TARRAWONGA LIFE OF MINE MODIFICATION – RESPONSE TO REQUEST FOR ADDITIONAL INFORMATION

Table 1 – Response to Response to Supplementary DPIE Request for Additional Information

Re: **Tarrawonga Coal Mine MOD 7 (PA11_0047
Mod 7) Request for Additional Information**

Figure 3 - mapped extent of alluvium and pit crest (after People for the Plains, 2020)

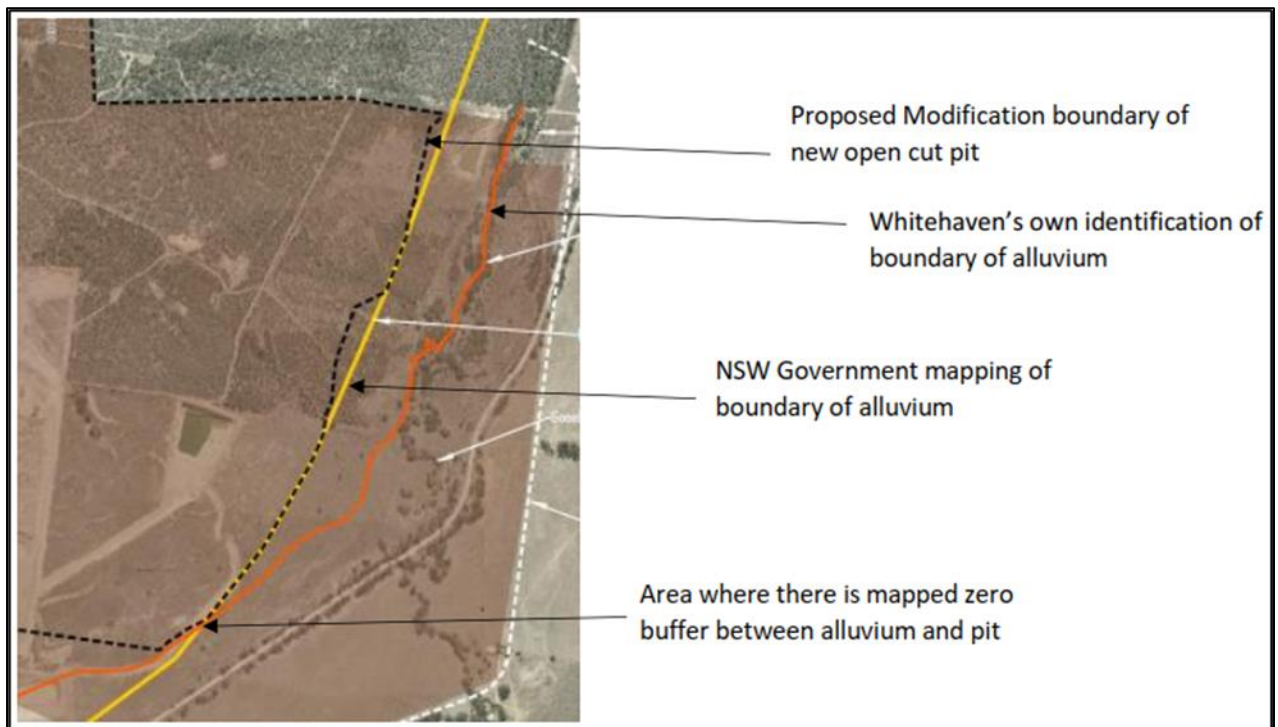
Comment	TCPL Response
After careful consideration, the Department requests that you provide the following additional information. clarification of the alignments/setbacks of the pit crest from the mapped alluvium and flood bund;	The alignment of the modified Open Cut pit extent sought under the Modification 7 application is shown as the “Modification Open Cut Extent” on Figure 1-3 of the Modification Report (refer to the dashed black line) (Whitehaven Coal Limited, 2020). This line is consistent with the Open Cut extent shown on Figure 5-2 of the Modification Report. Figure 5-2 shows that the Open Cut pit crest does <u>not</u> intercept the alluvial boundary mapped by SLR Consulting (2019) (i.e. the Modification will avoid mining the Upper Namoi alluvium).
consideration of the potential for leakage towards the pit and/or post mining void via the alluvium due to floodwater ponding against the flood bund and/or mapped alluvium;	This comment has been considered by Dr Noel Merrick of Hydrosimulations and a response is provided in Attachment 1. In summary, for a probable maximum flood (PMF) event, the magnitudes are estimated to be in the order of 20 megalitres (ML) for vertical recharge from floodwaters and about 2 ML for lateral flow of flood water beneath the flood bund towards the backfilled pit. Dr Merrick considers the potential risk associated with these scenarios to be very low. It is also noted that Tarrawonga Coal Pty Ltd (TCPL) holds 36 ML of licences in the Upper Namoi Zone 4 Namoi Valley (Keepit Dam to Gin’s Leap) Groundwater Source under WAL36548.

Figure 6 - Predicted 1% AEP and PMF flood extent (after HEC 2019, figs 29 & 30)

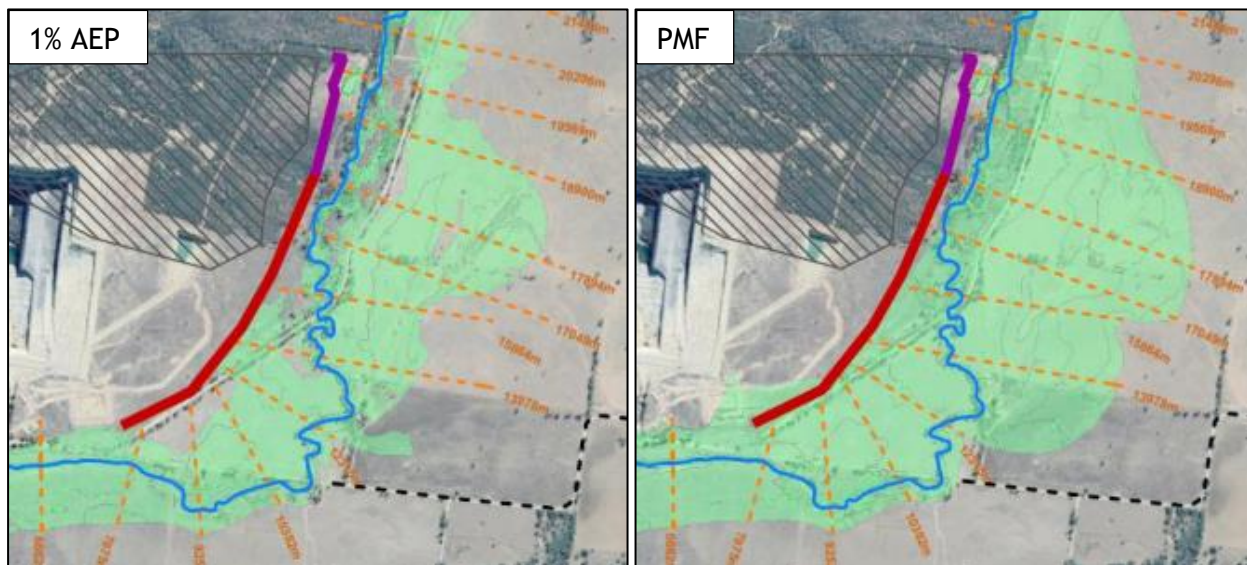
1. clarification of the alignments/setbacks of the pit crest from the mapped alluvium and flood bund;
2. consideration of the potential for leakage towards the pit and/or post mining void via the alluvium due to floodwater ponding against the flood bund and/or mapped alluvium;
3. consideration of potential pathways via fractured rock from blasting; and
4. consideration of any additional reasonable and feasible mitigation measures (such as keying the flood bund into the bedrock where it is located on the alluvium).

Figure 2 shows that, for the 1% AEP flood event, floodwater is predicted to abut the flood bund for less than 50% of its length overlying alluvium (about 350 m of 750 m). For the PMF event, floodwater would abut the entire 750 m length and would pass around the toe of the bund (as backwater) and abut the mapped edge of alluvium, but would not abut the backfilled pit.

As shown on **Figure 2**, there would be an opportunity for PMF flood recharge between the pit extent and the southern flood bund, although floodwater would not be in direct contact with spoil. There is negligible opportunity for the 1% AEP flood event.

Figure 2 shows that floodwater is predicted to abut the flood bund for a length of about 350 m for the 1% AEP flood event and for 750 m for the PMF event. Where floodwater abuts the bund, the flood heights calculated by HEC (2019; Table 33) range from 1.4 to 1.5 m for the 1% AEP event and 1.7 to 3.4 m for the PMF event (average 2.3 m).
